**Consultation Response from KC,  
Trees**
**2023/92892 35, Chadwick Crescent, Dewsbury, WF13 2JF**
**Erection of single storey side extension and alterations**
**Date Responded: 15/02/2024**
**Responding Officer: D. Atkinson**
**Responding Ref: 06/92**

Tree constraints plan at: Chadwick Crescent, Dewsbury	
1:500	PAPER SIZE A3
Key	
	Category A Tree
	Category B Tree
	Category C Tree
	Category U Tree
	Root protection area
• NST	Not Significant Tree - not included in survey because of low value and/or insignificance to local tree-scape

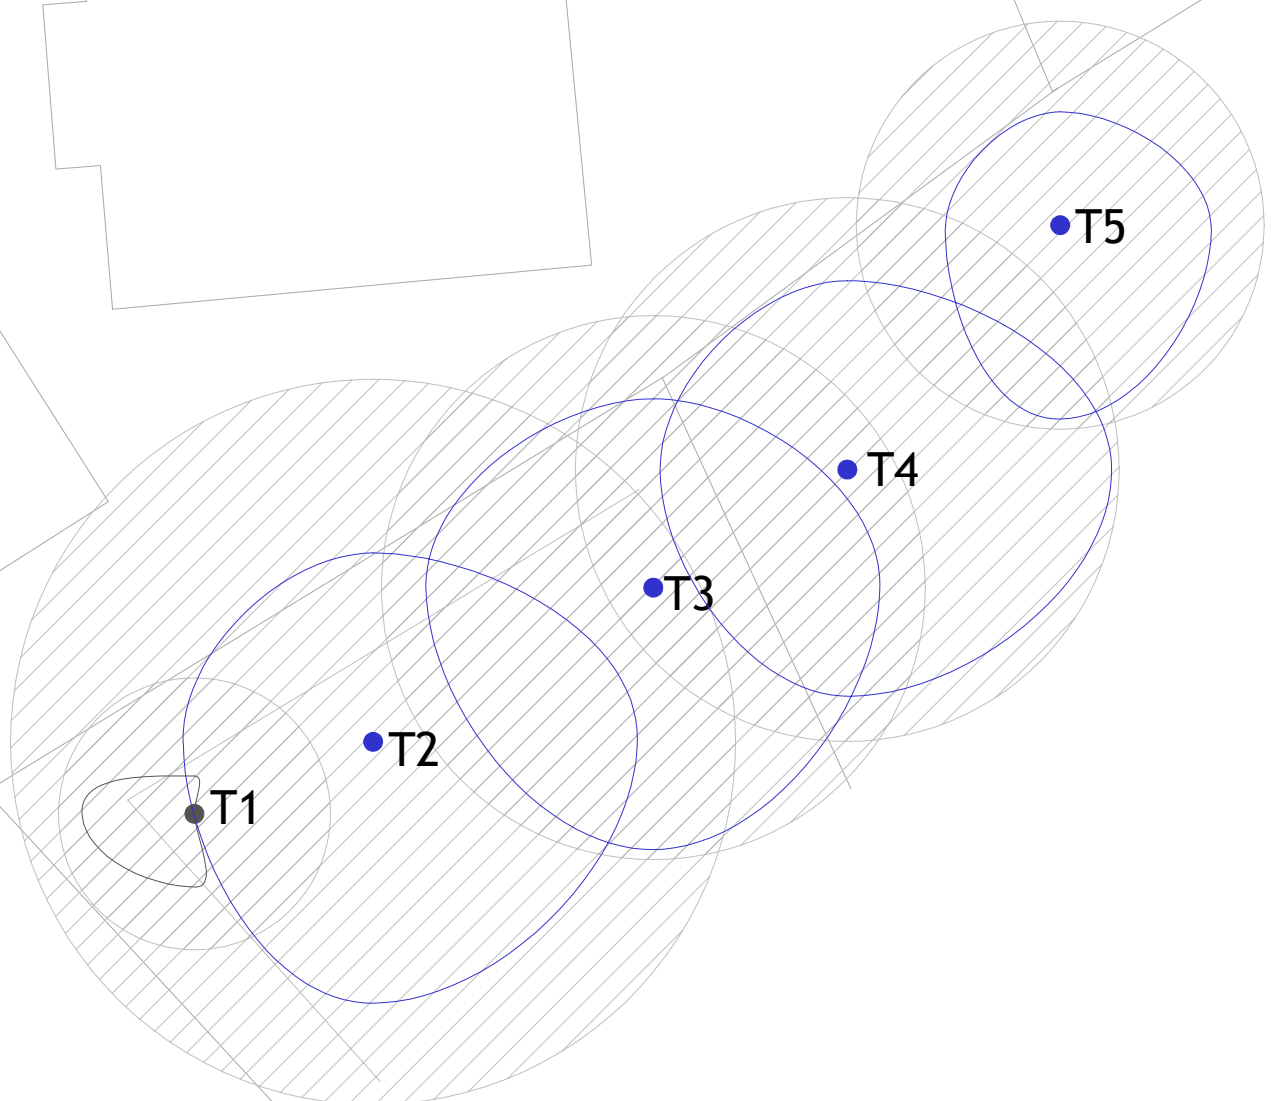
The RPAs of the trees on the tree survey, arb impact assessment and the AMS provided with the application are shown as squares and there doesn't appear to be an explanation as to why. KC trees are assuming it is formatting error.

The RPA for each tree should initially be plotted as a circle centred on the base of the stem. Where pre-existing site conditions or other factors indicate that rooting has occurred asymmetrically, a polygon of equivalent area should be produced. Modifications to the shape of the RPA should reflect a soundly based arboricultural assessment of likely root distribution.
